CITY OF ALBUQUERQUE

**Re: Premier Manufactured Homes, 600 San Jose Avenue SE,
Traffic Circulation Layout
Engineer's Stamp dated 10-01-12 (M14-D012C1)**

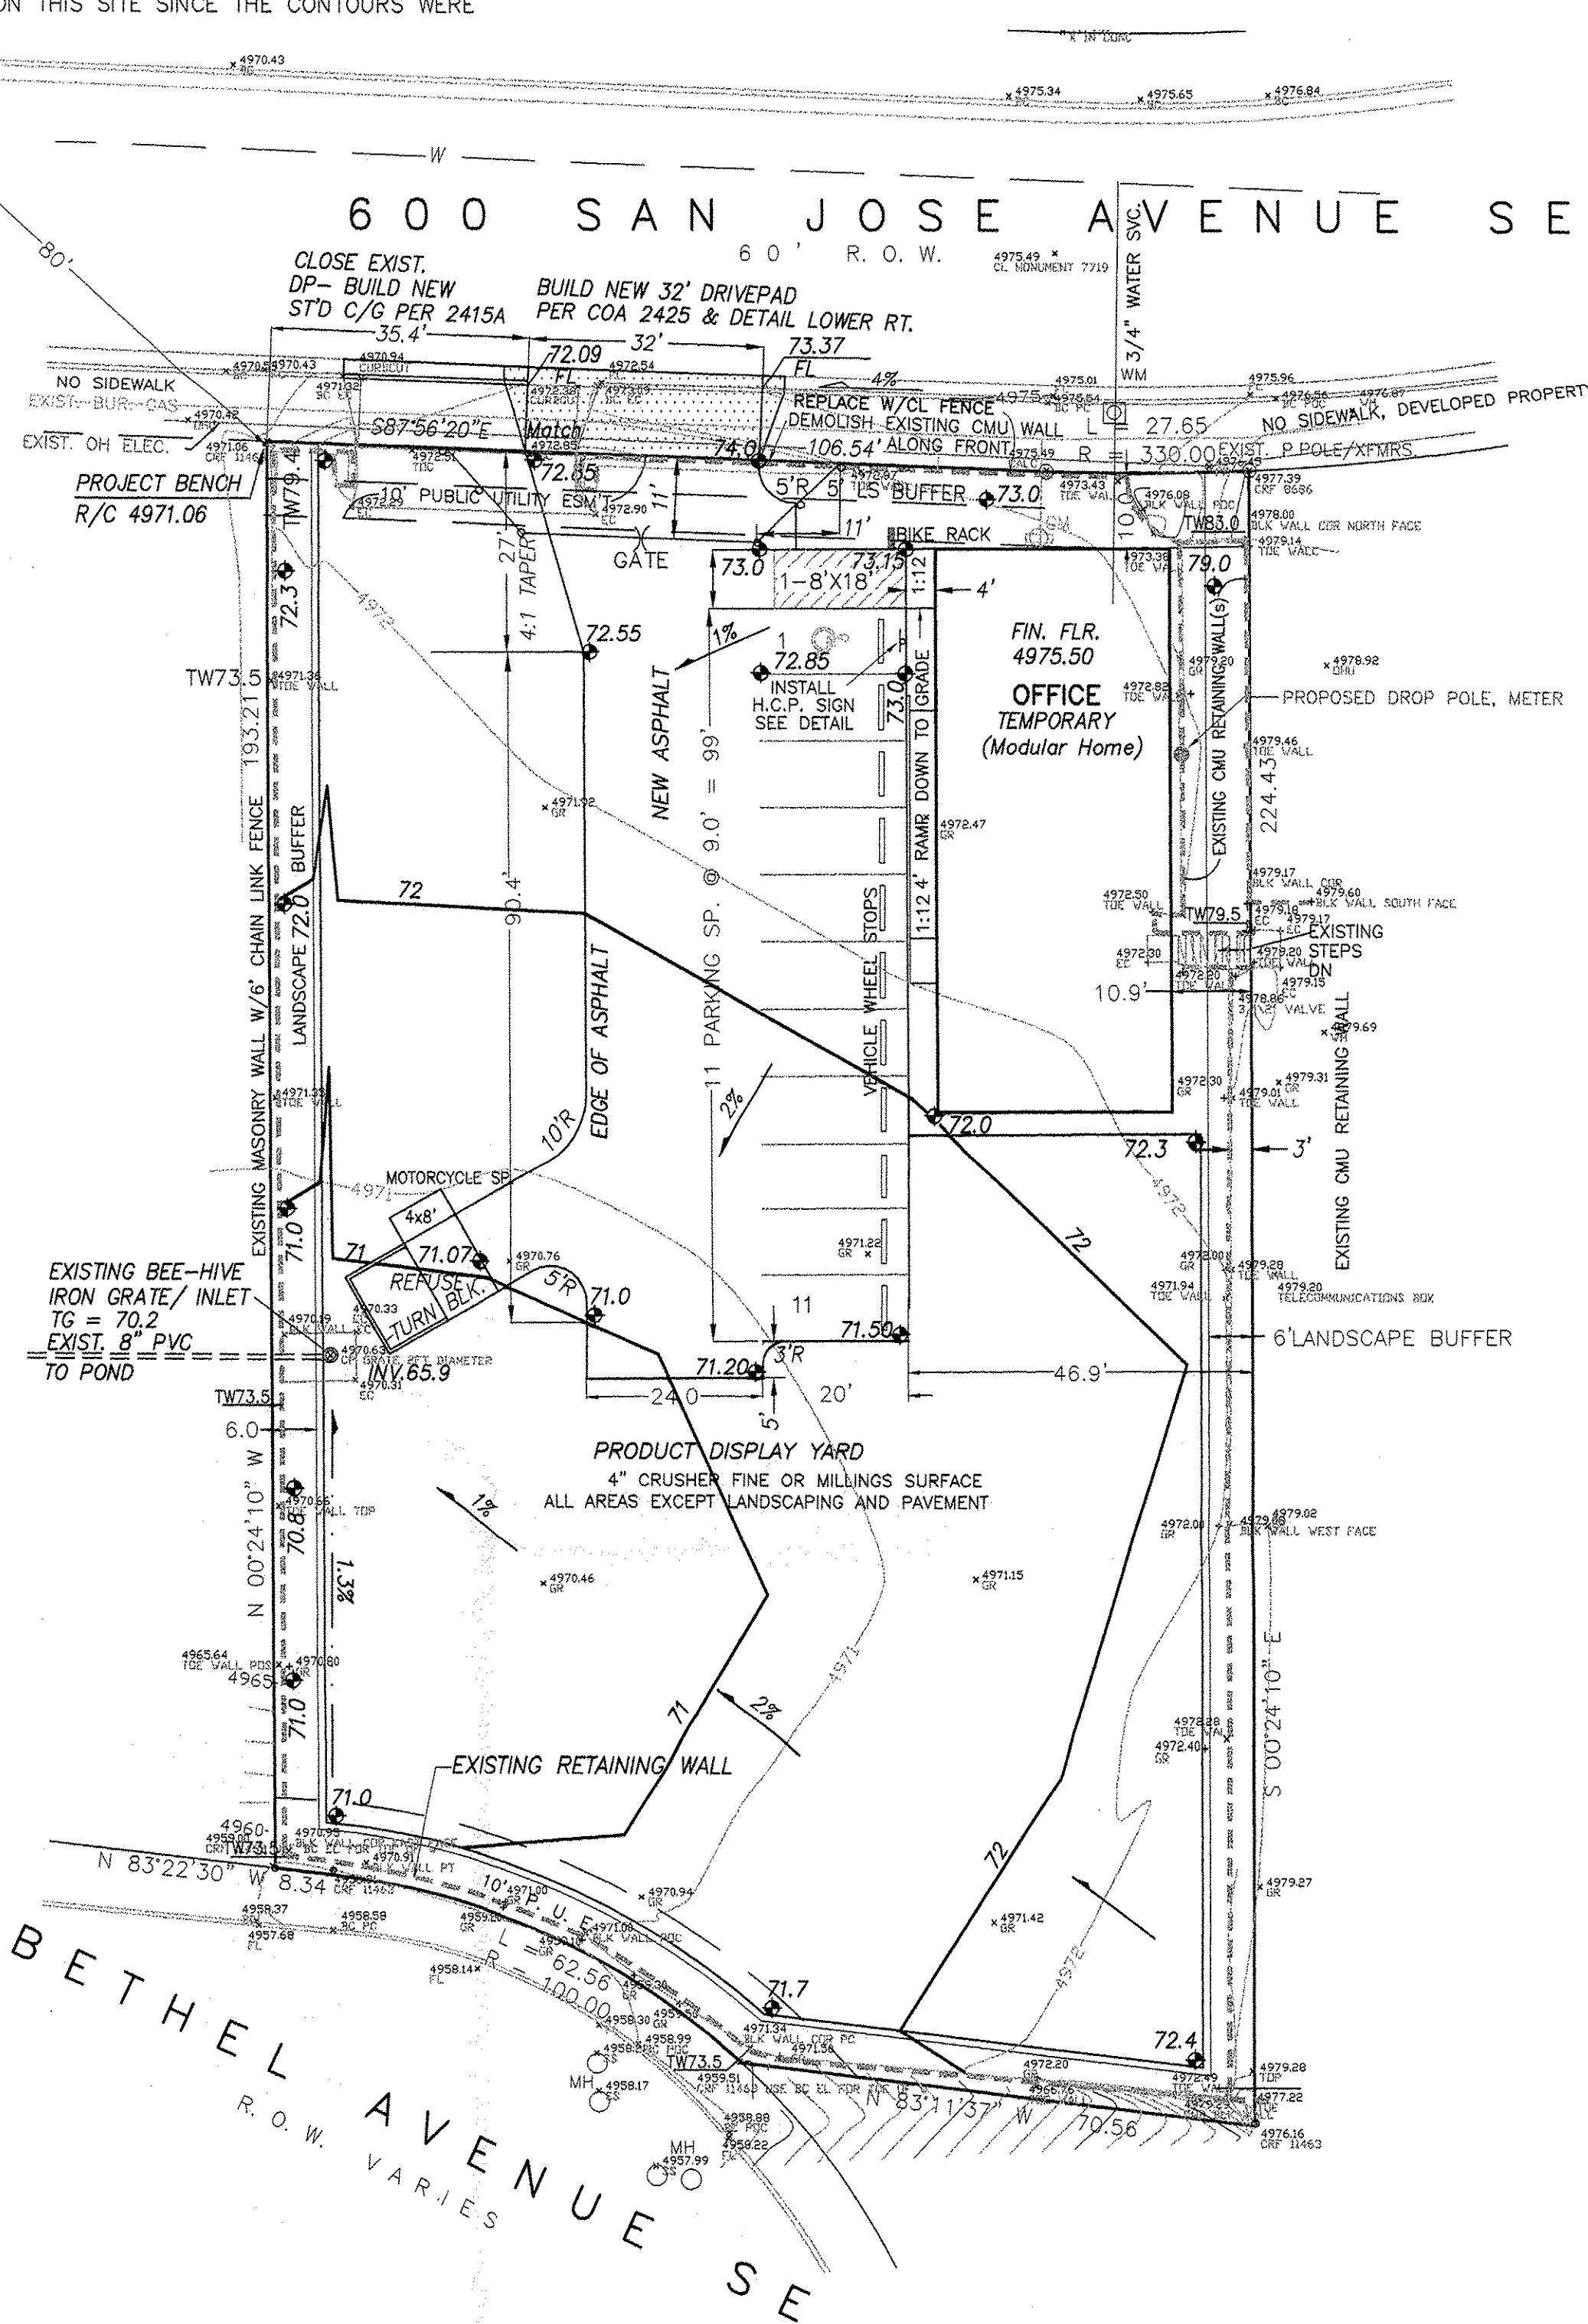
2. What is the width of the van access aisle?
3. Define the width of the proposed internal sidewalk.

ENTRANCE DETAIL

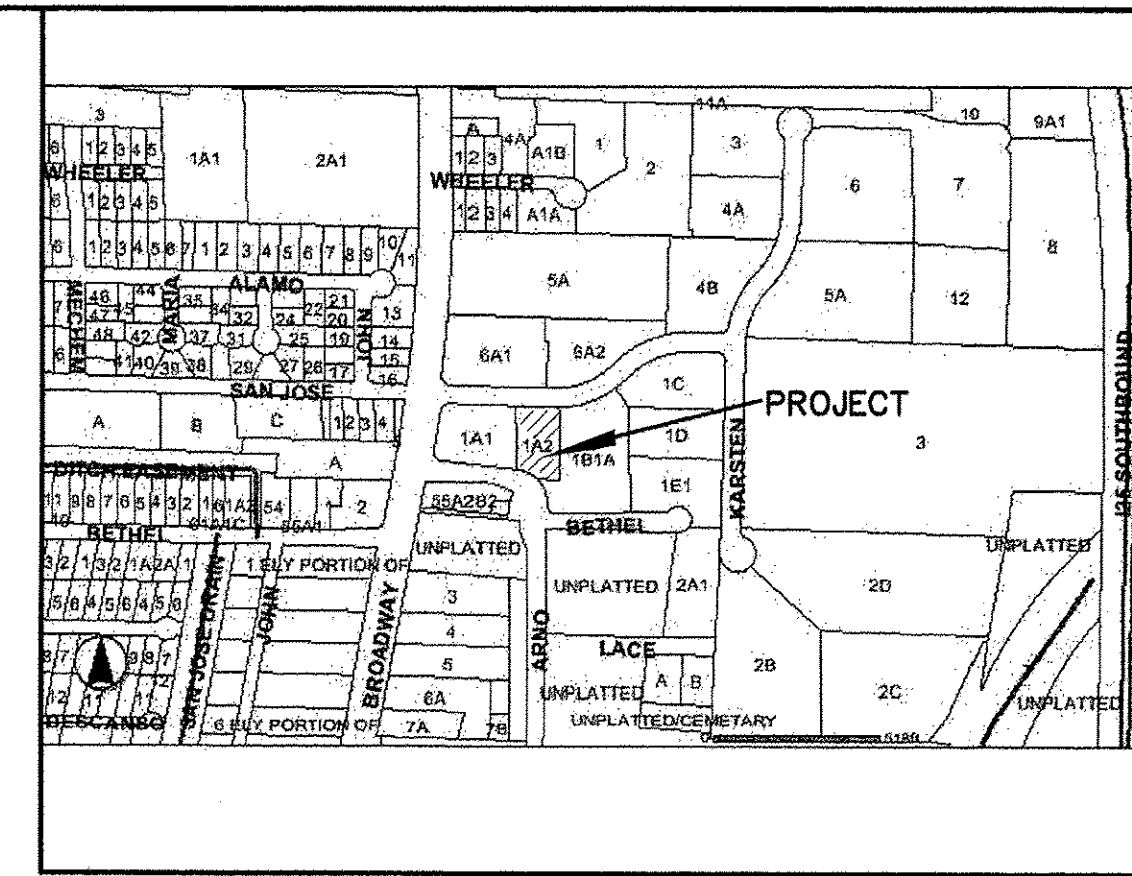
1. The proposed fencing may interfere with the sight distance of the driveway. Please provide a sight distance exhibit (see the *Development Process Manual*, Chapter 23, Section 6, Part B.12). Is a gate proposed at the entrance?
